Our Case Number: ACP-323799-25

**Re:** Proposed road improvement scheme  
at Newtownmoyaghy Stream, Kilkcok, County Meath.

Meath County Council/An Coimisiún Pleanála Ref TRA 04 023 12  
Newtownmoyaghy Road Improvement Scheme, Newtownmoyaghy,  
Kilcock, Co. Meath

**Observations on the proposed road improvement scheme**

Figure 3-2: Scheme Plan

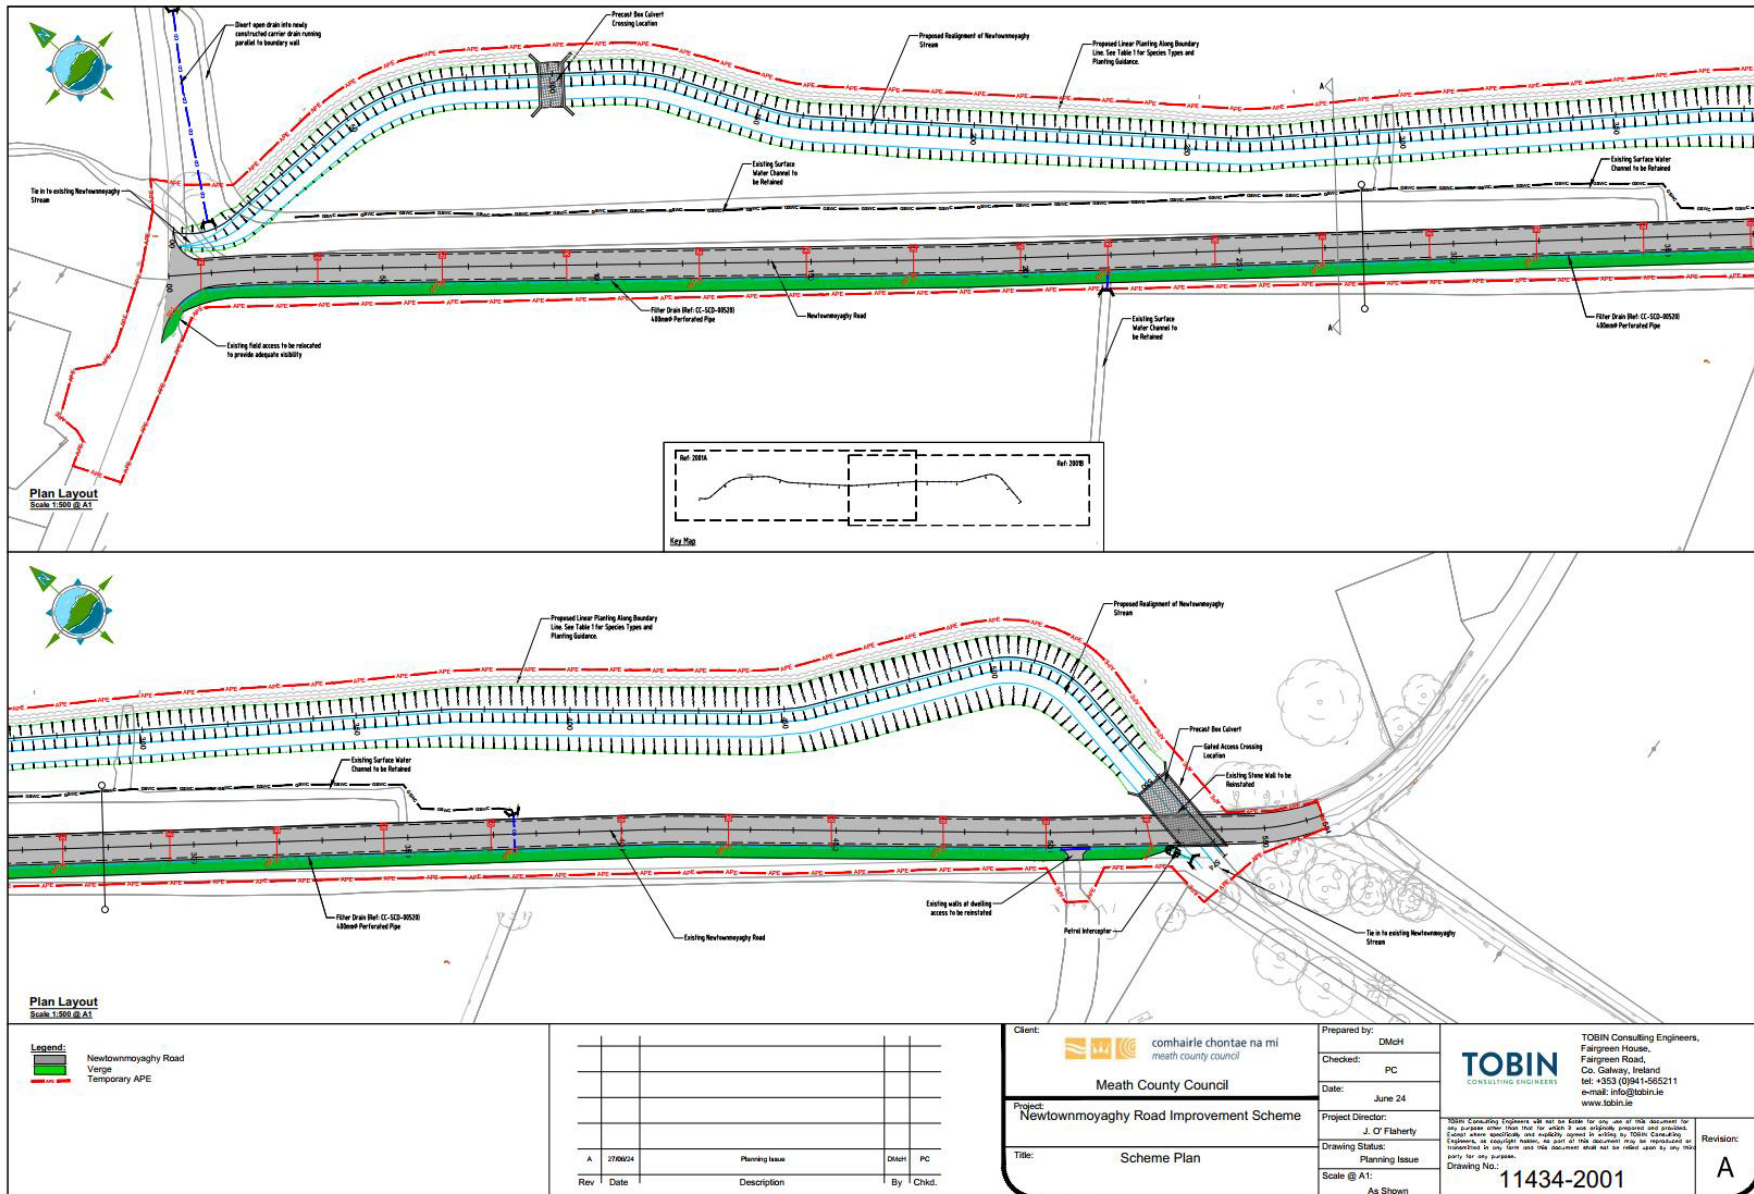
From the perspective of the stream, the proposed scheme represents a major change in its hydrological regime. At the northern end of the scheme it is proposed to route the stream through a right angle into a wide (13m+), two tiered channel, although still separated from the field drainage. This new stream channel, some 850 long, will reconnect to the original stream channel at the southern end. This re-routing represents a major change in the hydromorphology of the stream. Given the good status of the water quality/habitat of the stream in the recent Water Framework Directive (WFD) review (2016-21), eliminating this habitat by filling in the old stream represents a significant environmental impact. The proposed scheme will clearly put at risk the requirement under the WFD to maintain that status by 2027. In any case altering the stream course as proposed comes under the remit of Article 9 of the Arterial Drainage Amendment Act (1995), requiring an application to the OPW (which is not apparent in the planning documentation). The proposed scheme does not accord with principles of nature restoration, as established under the EU Nature Restoration Law.

The land-take from the agricultural field to the east to accommodate the proposed scheme/channel diversion has an additional environmental impact, not addressed in the planning documentation.

Re-routing the stream into a completely new channel in the field to the east of the current route is not only a negative environmental impact but a major impact on the utility of the then riparian land. Irrespective of the present zoning, a re-routed stream will effectively sterilize future access to the land from the newly widened road. Any future development would be significantly affected by such restriction of access, reducing the value of the land. Bridging the wide, newly proposed channel would be a prohibitive cost.

Figure 7-14 Flood Extents for Existing Scenario [10-,100-, & 1000-Year]

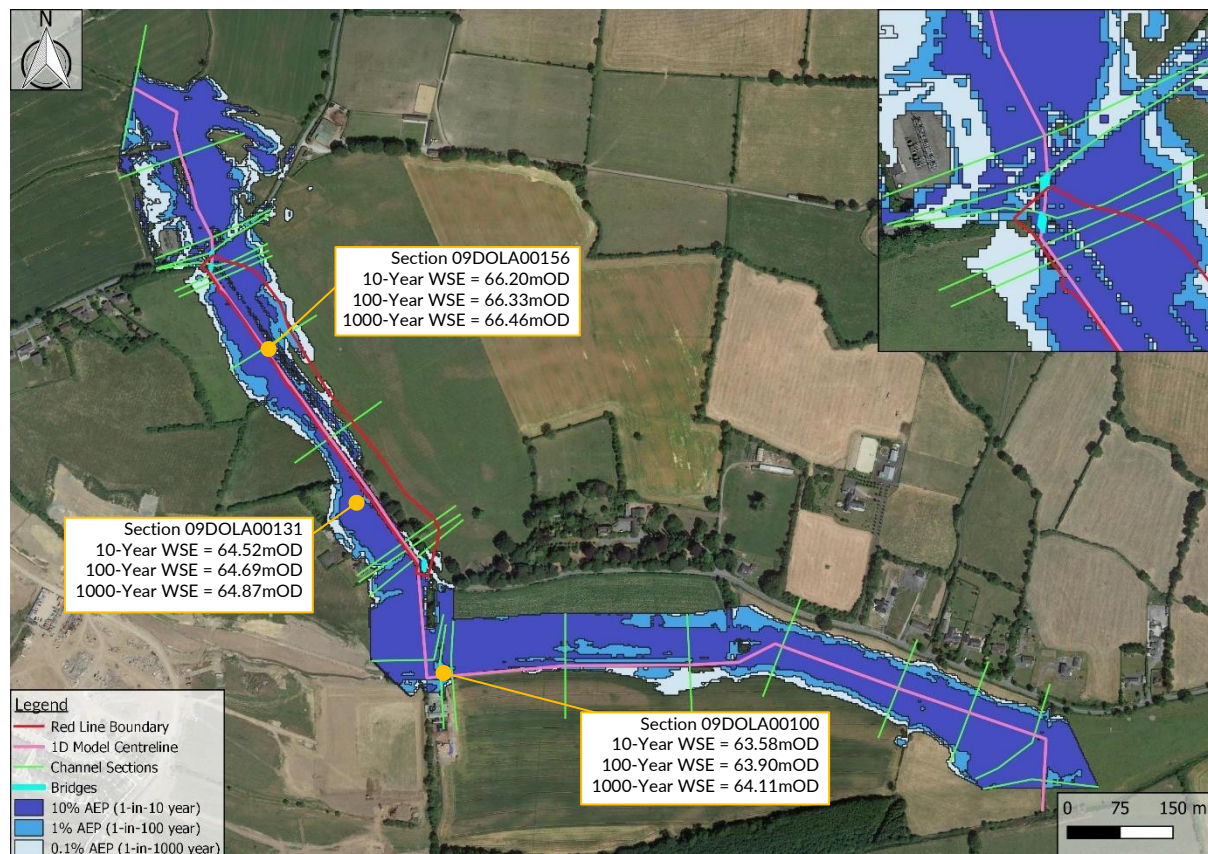
The flood analysis undertaken as part of the assessment of the proposed scheme has used conventional rainfall-runoff catchment modelling along with hydraulic routing to indicate the benefits of re-routing the stream. As acknowledged, the modelled results are indicative, since there is little opportunity for validation in the field. However, even the reported results also acknowledge that there is a residual chance of flooding under extreme rainfall events, particularly at the northern end of the scheme.

The modelling as presented concentrates on the sources of the flooding (ie extreme rainfall) on a catchment basis, routed hydraulically through the present channel conditions. It is clear that a principal control on the flow into the stream along the road is the pair of stone arch bridges at the northern end. The constriction of the arches limits the flow into the downstream channel but is also a factor in causing upstream flooding, above the bridges (not part of the scheme). However, the observed *causes* of the flooding now experienced along the road is multifarious. Road runoff, overspilling of field drainage (particularly at the northern end) and an overgrown stream channel are significant causal factors which are not necessarily taken into account in the modelling. Re-routing the stream into a much wider/deeper channel would seem to be a 'sledgehammer to crack a nut', at the same time as causing a significant environmental impact.

Figure 7-15 Flood Extents for Proposed Scenario [10-, 100-, & 1000-Year]

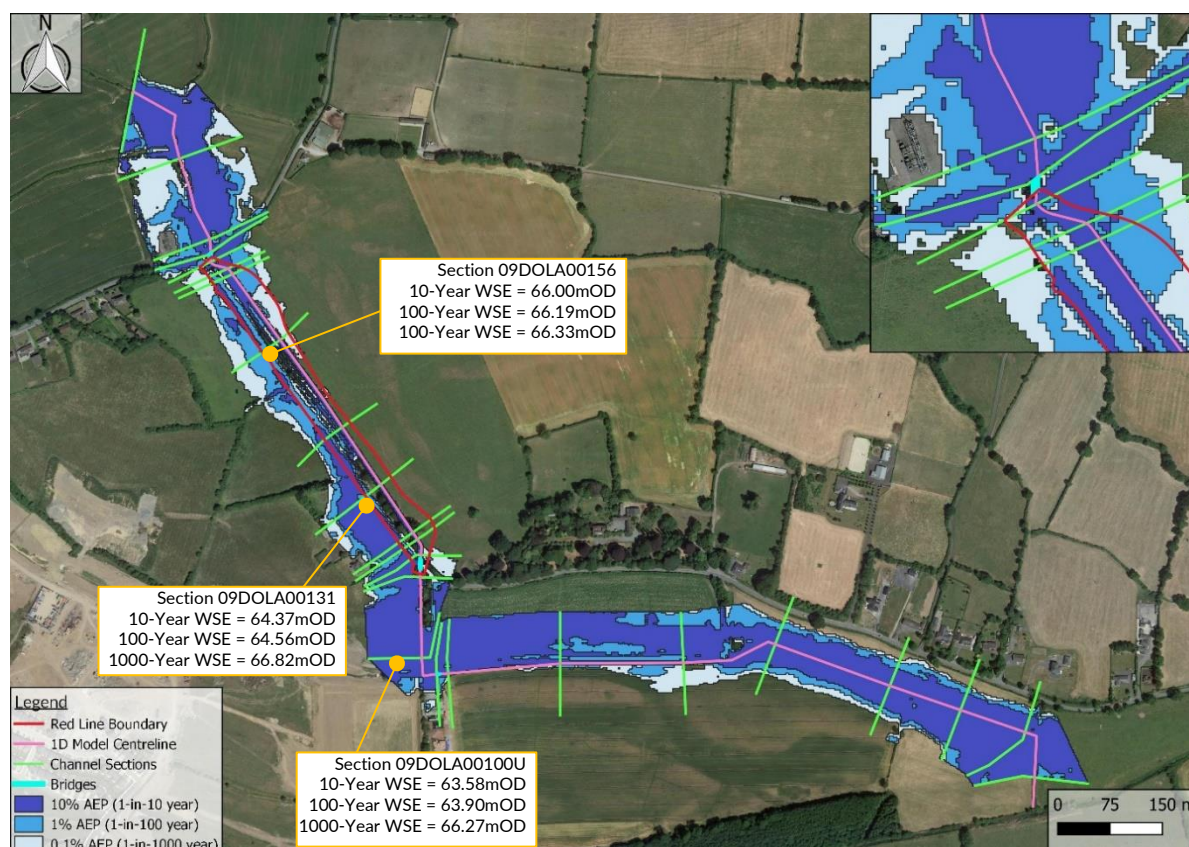
The proposed stream re-alignment under this road improvement scheme is not justified under environmental grounds. Even the flood modelling indicates it will not fully solve the flooding problem under more extreme events, as expected under climate change. A more thorough investigation of the situation in the field is needed coupled with an analysis of alternative solutions to accommodate both road improvement and environmental concerns, is required. The acquisition of a land-take on the east side of the road is not warranted under the circumstances.
